Your Ref: OWPC2572
Our Ref: A/46/14/HH 31-03-2014
Please ask for:
Mr P Cleveland

Retention of infill Brickwork to front boundary wall. This application affects the character and appearance of Angmering Conservation Area
Woodford Villas 2 High Street Angmering

Thank you for your internet representation made on 24th April 2014 which has been recorded as '**an objection**' with the comments as follows:

DRAWING TITLE
NEW FRONT BOUNDARY WALL
ELEVATIONS, PLAN AND SECTION

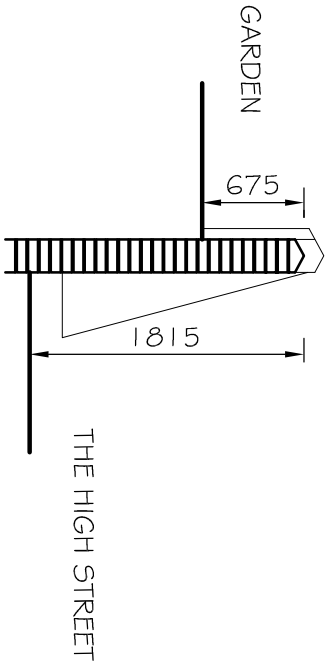
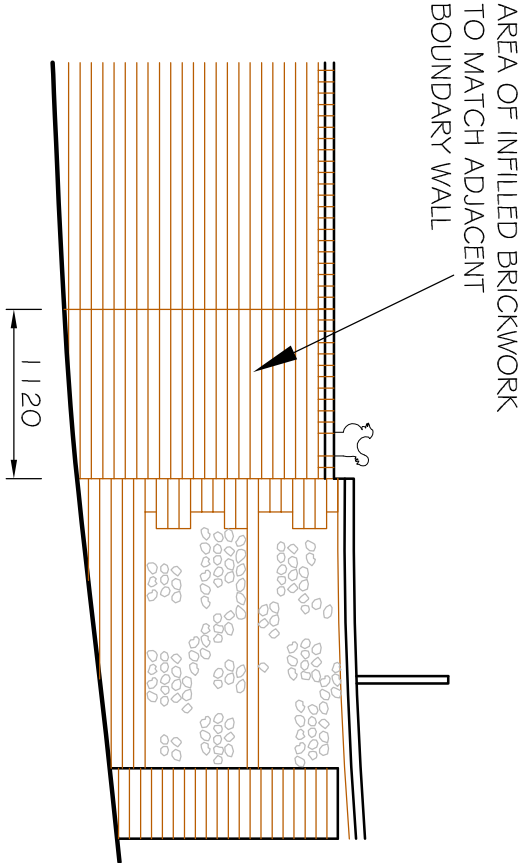
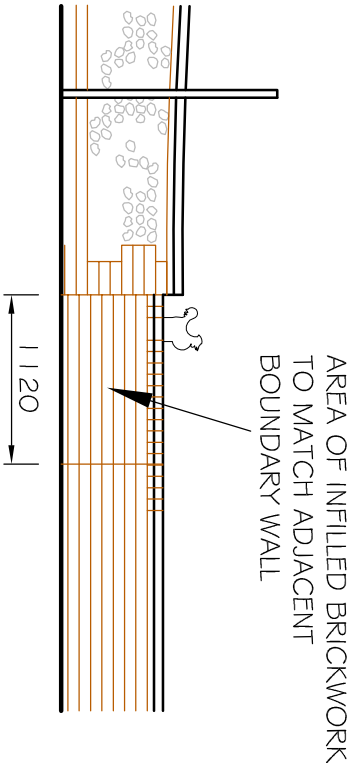
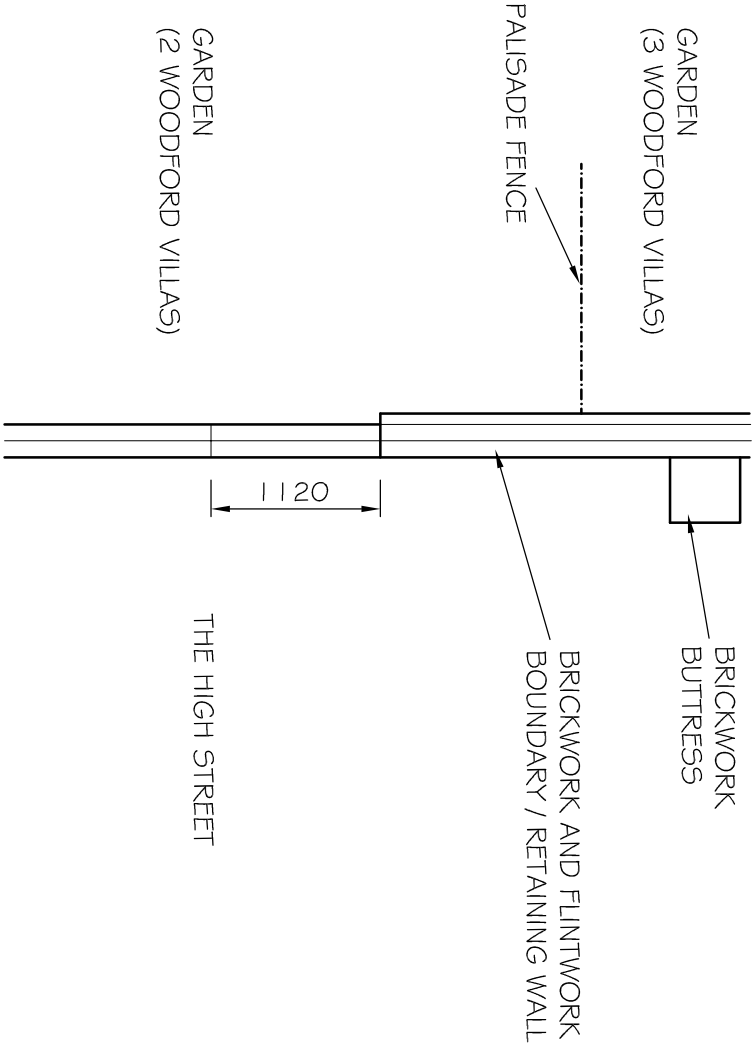
While I do not have any objection to the infill of the wall - which has been carried out before planning consent has been granted - I do strongly object to the stupid terracotta chicken that has been built into the wall capping. This is totally out of character with the Conservation Area.
